Energy and Resource Assessment  
Department of Planning, Industry & Environment  
GPO Box 39  
SYDNEY NSW 2001

**Dendrobium Mine Extension Project- Environmental Impact Statement  
Areas 5 & 6**

C. Salkovic  
Executive Engineer  
NSW Dams Safety Committee

Drawing 6

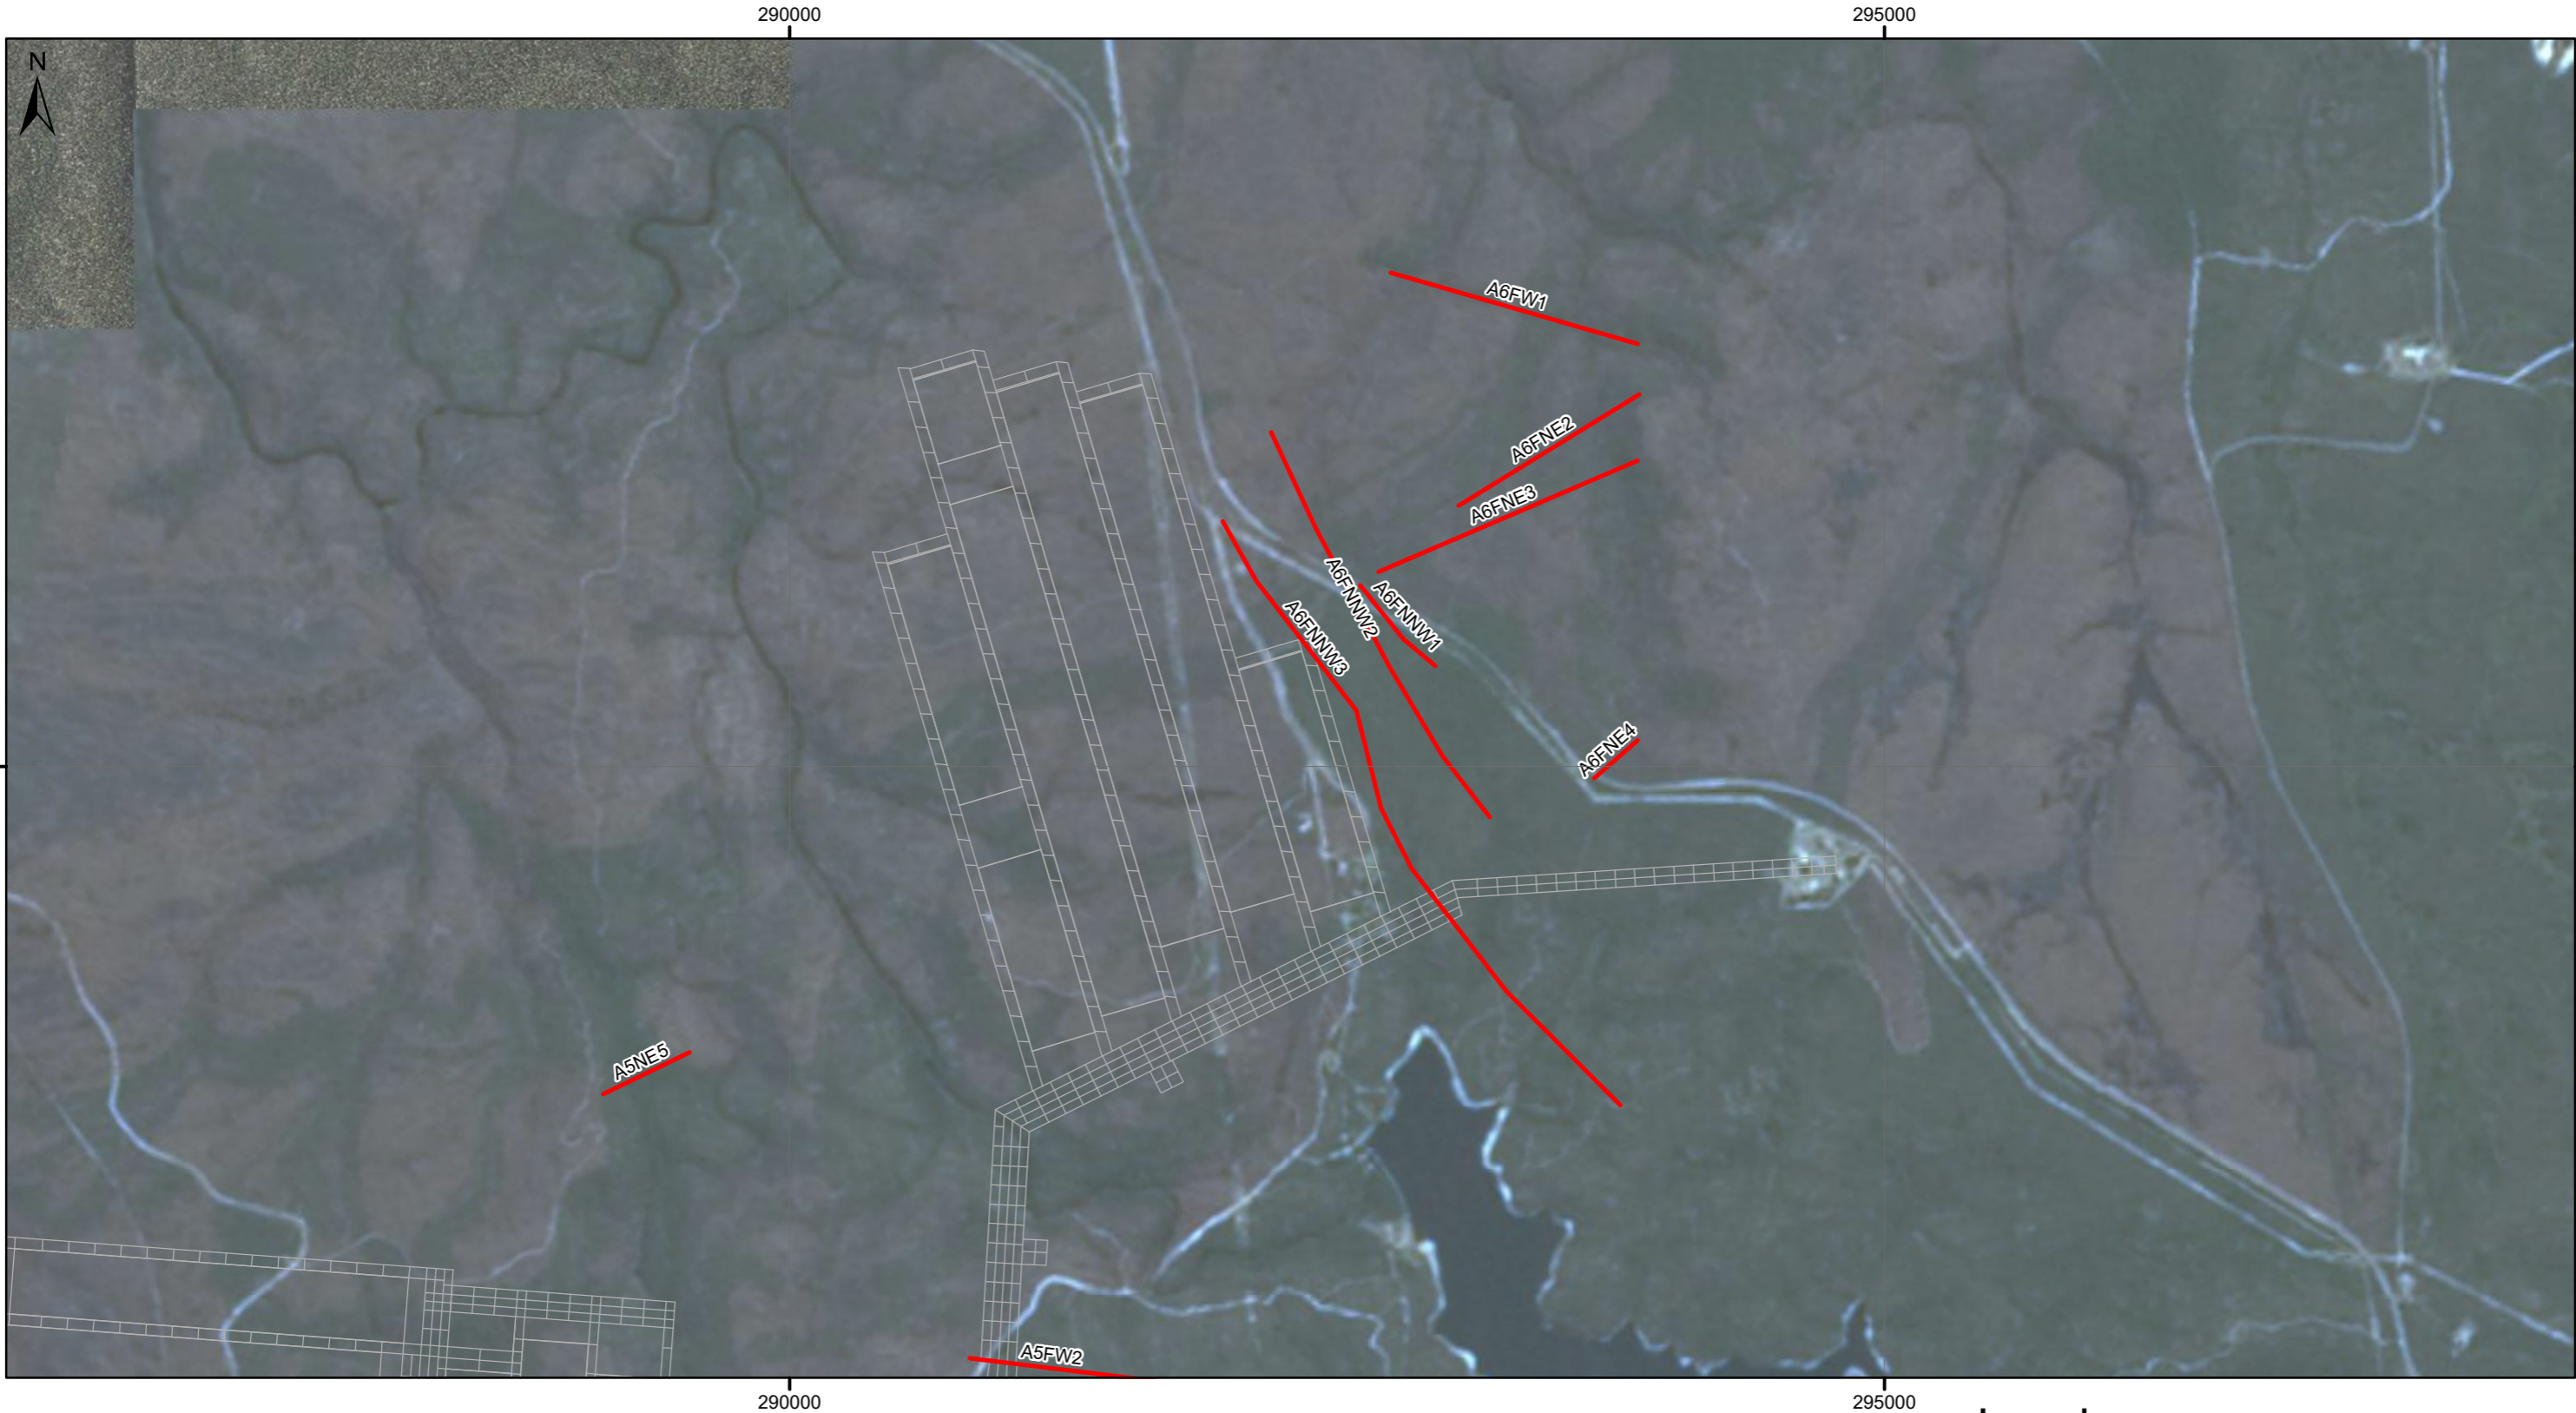
Geology plans in the EIS show two dykes below the Cordeaux Dam Wall. The above discussion of differential movement on the Cordeaux Dam Wall also applies to the foundation of the dam. This would place the dykes below the dam in tension. What impact will the proposed mining have on the stability of these dams with geological structures present in the foundations? This has not been addressed in the EIS.

Figure 1 Measured incremental far-field (absolute) horizontal movements at Dendrobium Mine and elsewhere in the Southern Coalfield (Source: Fig. 4.4 from MSEC, 2019)

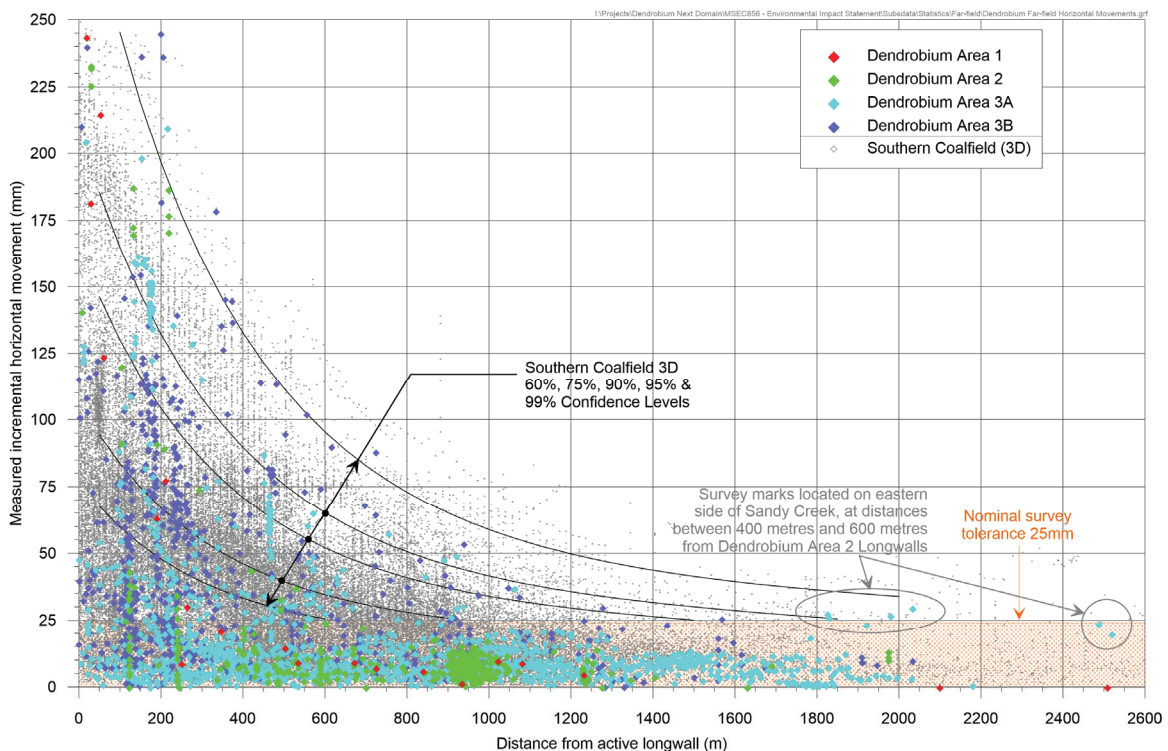
Figure 4.4 of the MSEC856 report reproduced below shows horizontal movement plotted against distance from active longwall. Given the extreme consequence of the dams it is appropriate to use the 99% confidence level to predict movement at the dam wall for a set distance from the longwall goaf.

As the long axis for both dams are aligned with the long axis of the longwalls there is differential movement between the left and right abutments of the dam walls.

For Avon Dam with a crest length of 223m at 1000m from Area 5 longwalls, the chart above predicts the right abutment moves 10mm more towards the goaf than the left abutment.

For Cordeaux Dam with a crest length of 405m at 1000m from Area 6 longwalls, the chart above predicts the right abutment moves 16mm more towards the goaf than the left abutment.

The differential movement on the dam walls could cause cracks to open in the dam walls.

**To reduce the likelihood of cracking the dam walls, longwall extraction should approach no closer than 1,500m to the dam walls.**

**An assessment by an appropriately qualified Dams Engineer is required to determine if the longwalls should be moved further away from the dam walls.**
